CITY OF ELLENSBURG
Public Works & Utilities Department
501 North Anderson Street; Ellensburg, WA 98926
Ph: (509) 962-7124 Fax: (509) 925-8662
www.ci.ellensburg.wa.us

Memorandum

Date: March 30, 2021
To: Jeremy Johnston, Kittitas County Community Development
From: Darin Yusi, Gas Engineer 
Re: Proposed Bull Ranch Development Project

The following are the City of Ellensburg Gas Division comments on the proposed Bull Ranch Development off Bull Rd and Kittitas Hwy.

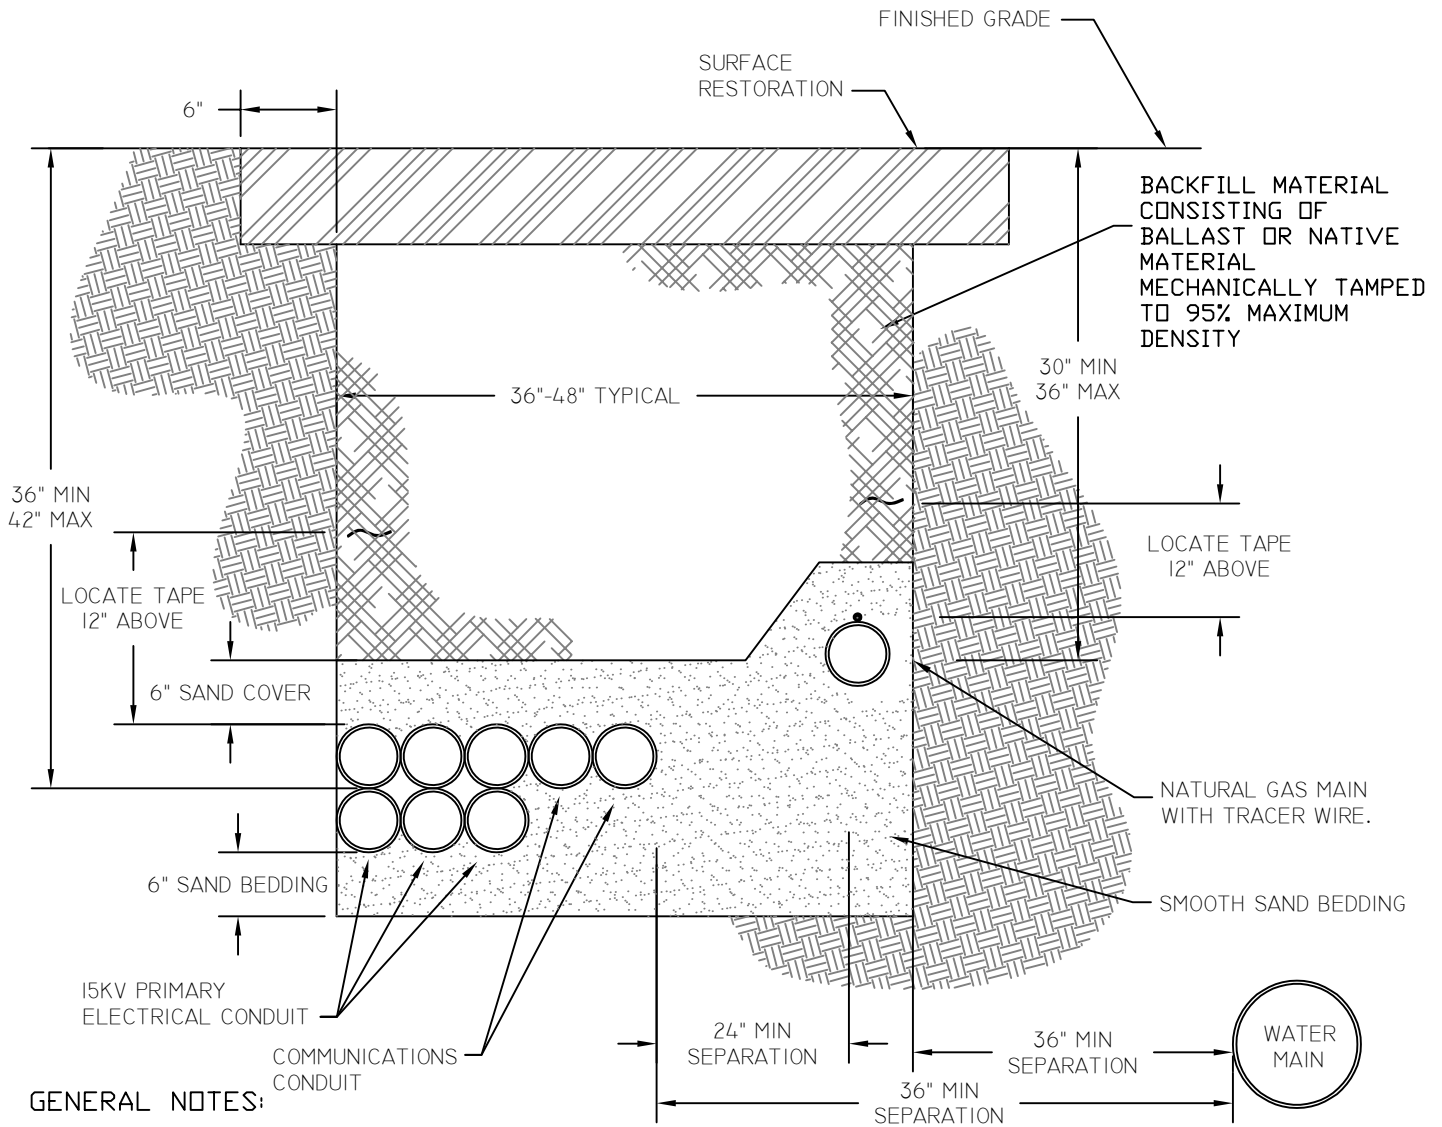
The proposed development will be required to tie into the main on Bull Road and extend the gas main throughout the development and provide service stubs to each lot. The mainline will also need to be looped into the 6-inch main on the North side of Kittitas Highway. The developer will need to provide the road crossing, appropriate traffic control, and roadway/sidewalk restoration. A natural gas utility map is included with these comments.

G-12

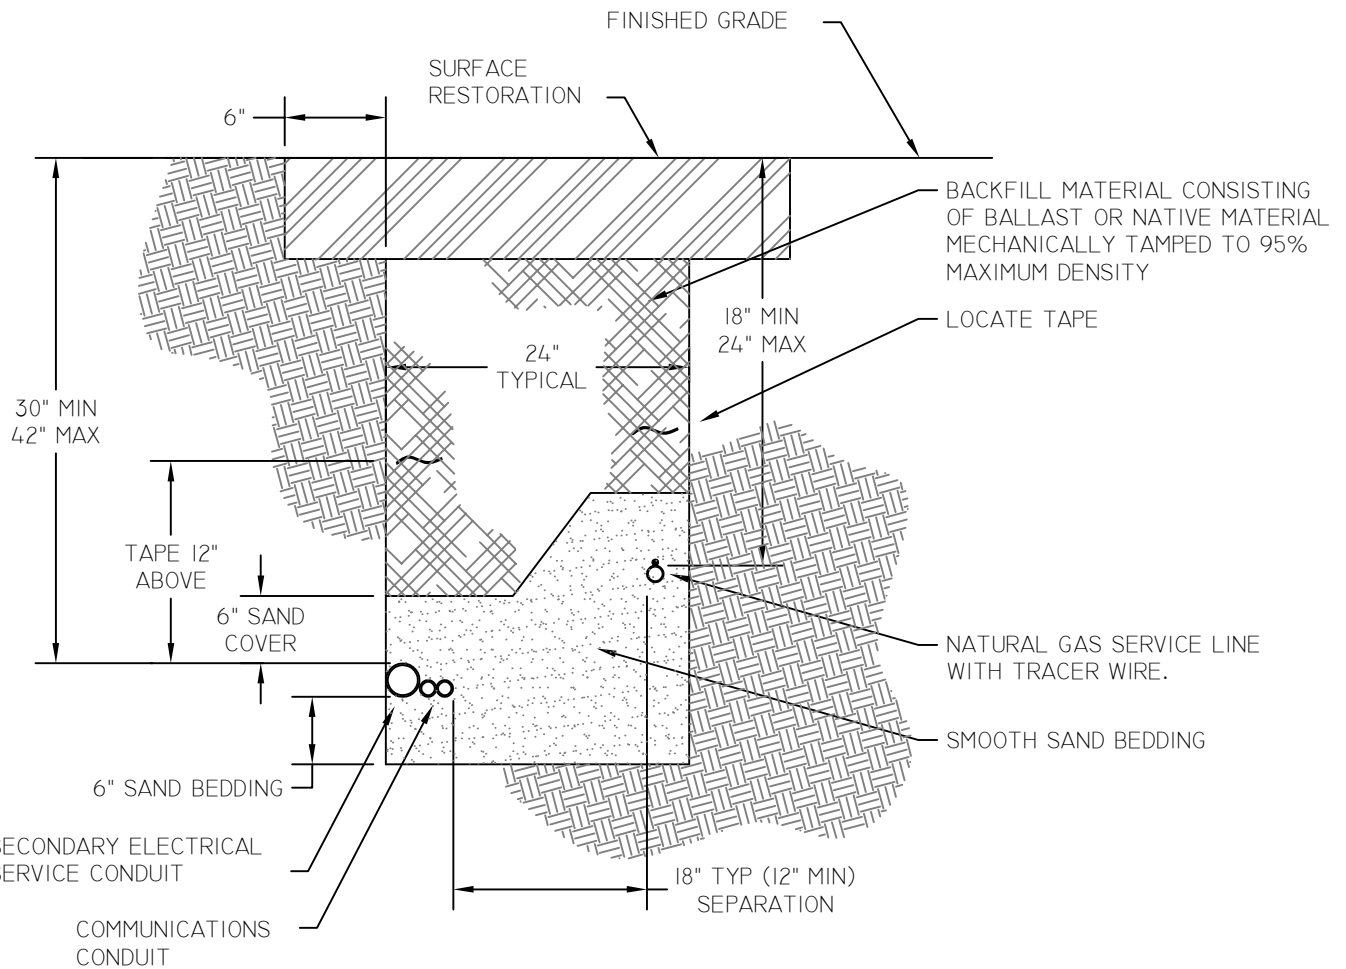
City gas crews will install gas main and service stubs in developer provided trenches. The applicant is to provide the trench, smooth sand bedding, and backfill at the specified depth and required utility separation as indicated on the details G-12 and G-13.
